Paddington United Submissions to Application Number SSD-97528708

Submission to Application Number SSD-97528708
Mixed Use Development with Infill Affordable
- 160 Oxford Street, Paddington

Figure 28 3D axonometric of the maximum 22m (LMR) + Affordable Housing bonus (blue) and height exceedance (view from south east – right, view from south west – right)

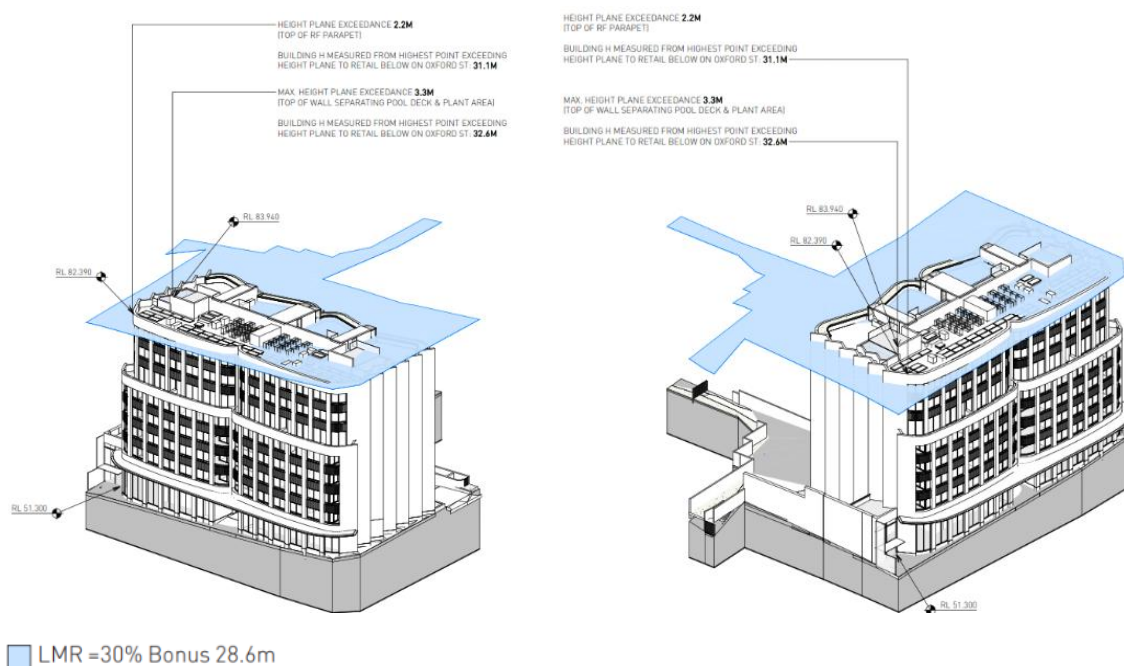
Excessive Height and Scale: At 9+ floors (8 at front, 9 at rear + rooftop), and ~50 metres wide, the bulk and scale is too significant for the surrounding Heritage Conservation Area, and is not replicated elsewhere on Oxford Street. The 4.6 Variation (+4 metres, a 14% increase) is not supported primarily because the height is already out-of-scale with its context. Even if the variation is considered in isolation, the EIS fails to demonstrate why compliance with the height limit is unreasonable or unnecessary.	Annexure B and Clauses 3.8 (Excessive Height) and 3.9 (Variation)
---	---

7.	Height and scale reduction	The height is not to exceed 4 floors.	Clause 1.4 (SEARs Requirements) at Clause 6 of the SEARs Requirements (Built Form and Urban Design). Chapter 3 (Incompatible with a Heritage Conservation Area). Annexure B. Clause 1.4 (SEARs Requirements) at Clause 7 of the SEARs Requirements (Environmental Amenity). Clause 4.7 (Amenity Impact to Shadforth and Gipps Streets). Clause 1.4 (SEARs Requirements) at Clause 8 of the SEARs Requirements (Visual Impact). Chapter 5 (Congestion Impact).

Figure 31 Proposed building separation distances to adjacent residential buildings

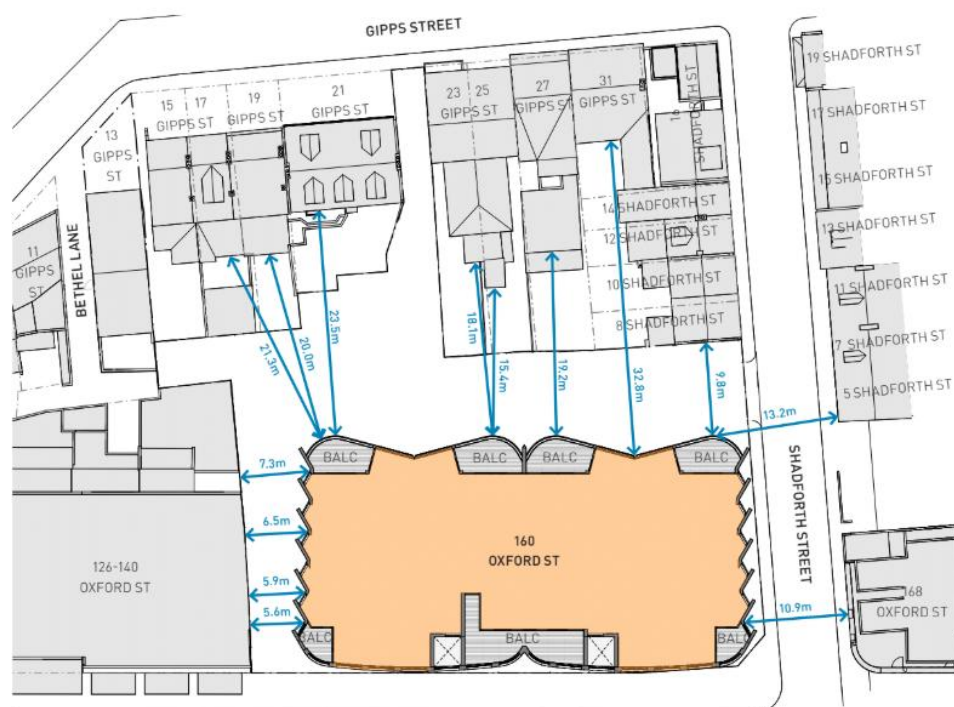
ADG: The development falls well short of building separation requirements in the Apartment Design Guide (under 9 metres at junctures to R2 zoned land, when 15 metres is required).	Clause 6 of the SEARs Requirements (Built Form and Urban Design) (2F (Building Separation))
Amenity: It does not maintain the mandatory “high” degree of amenity to adjacent dwellings, particularly with respect to overlook, privacy and noise. There has been no assessment of the visual impact from such adjacent dwellings, or of “light spill” from the building to those dwellings, to demonstrate that high amenity is retained.	Clause 4.2 (Significant Amenity Impact)
Congestion: The consistent experience of residents is the area is already at capacity. This would create an unreasonable traffic congestion on narrow laneways constructed in the early 1800s which were not designed for a building of this intensity, and are already highly congested. There is no description of the constraints/accessibility of surrounding streets and any assessment provided is limited to traffic volume during a prescribed period.	Clauses 5.3 (Description of Shadforth and Gipps Streets) and 5.4 (Congestion as Observed by Residents and Local Business) and 5.5 (Traffic Assessment Report).

The proposal is well short of Apartment Design Guide separation requirements and comes within 9.8 metres of 8 Shadforth Street in the adjoining R2 zone (and under 9 metres at two other points). The minimum 15 metre separation should be maintained, with relevant set-backs for higher floors. This would materially improve privacy, outlook, light, visual relief, and the transition in scale between the proposed building and the surrounding smaller cottages.

9.	Apartment Design Guide building separation	Building separation to be in accordance with the Apartment Design Guide (including for higher floors).	Clause 1.4 (SEARs Requirements) at Clause 6 of the SEARs Requirements (Built Form and Urban Design).
